Consultation Response from: KC Environmental Health (Pollution & Noise Control)		
2025/92913 - 393 Bradford Road, Fartown, Huddersfield, HD2 2QY		
Change of use of dwelling (Use Class C3) for provision of education hall or meeting place for the principal use of the local community (Use Class F1) including erection of open sided structure to rear		
Responding Date: 22 January 2026	Responding Officer: Mohammed Nasim	Responding Ref: WK2025
<p>The applicant has submitted an undated and unreferenced Planning Statement along with a Noise Impact Assessment (NIA) authored by Noise Assessments Ltd dated 28 November 2025 Ref NALPRO191125.01 in support of the proposal.</p> <p>The Planning Statement states the proposed hours are -</p> <ul style="list-style-type: none"> • During the month of Muharram and Ramadhan, and occasional religious gatherings - <ul style="list-style-type: none"> – Sunday to Thursday - 1630hrs to 2130hrs – Friday and Saturday - 1100hrs to 2130hrs • Rest of the year - <ul style="list-style-type: none"> – Sunday to Friday - 1630hrs to 1930hrs – Saturday - 1100hrs to 1930hrs <p>The applicant proposes to limit the number of users to 40 individuals.</p> <p>The NIA describes th

Ground Floor Layout 1:50

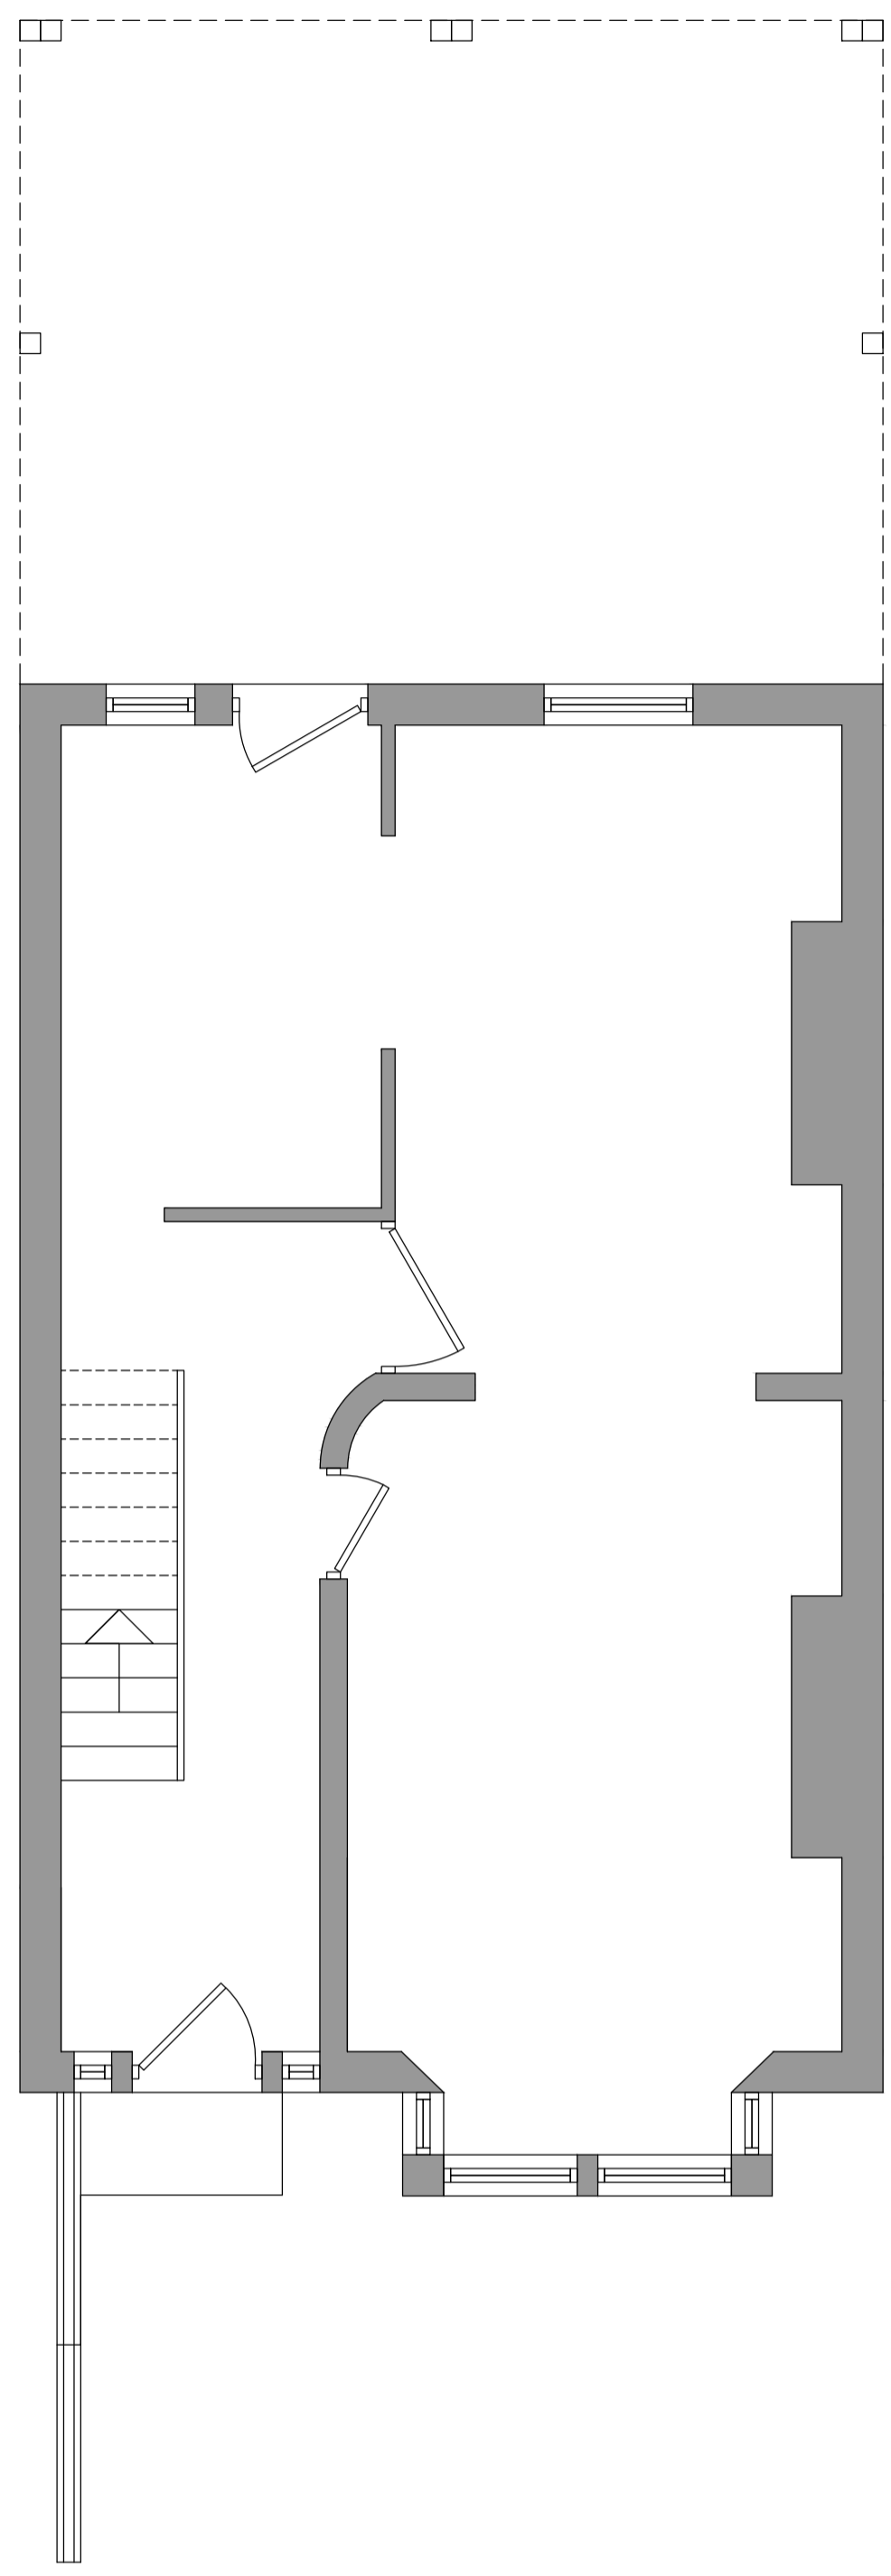
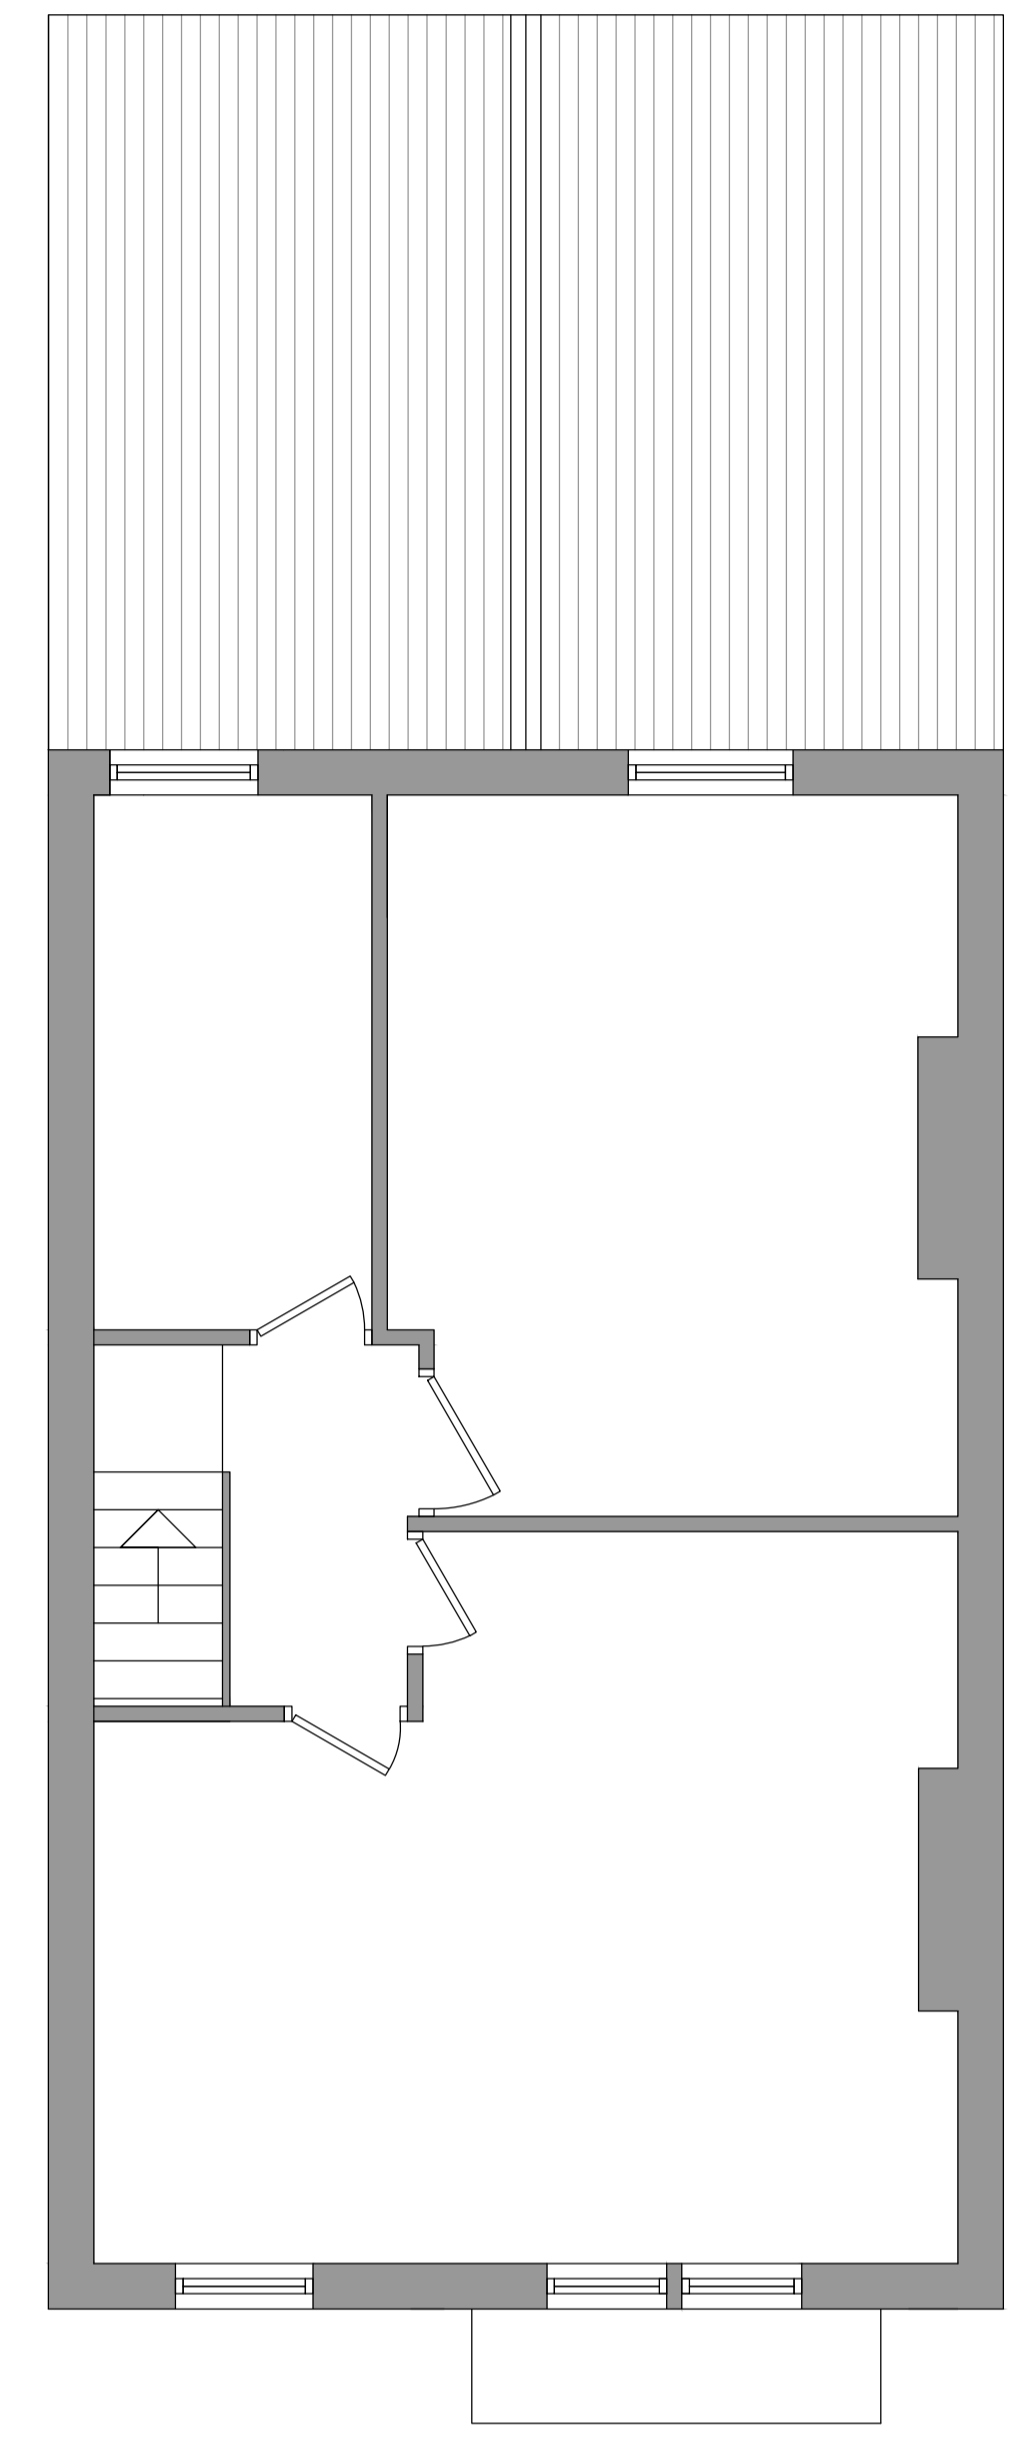
Whilst the NIA recommends works to the party wall, it is unclear if this is to the ground floor only. There is some uncertainty on the numbers of users upstairs so this work will be required to both floors in order to prevent flanking sound transmission to the neighbouring property.
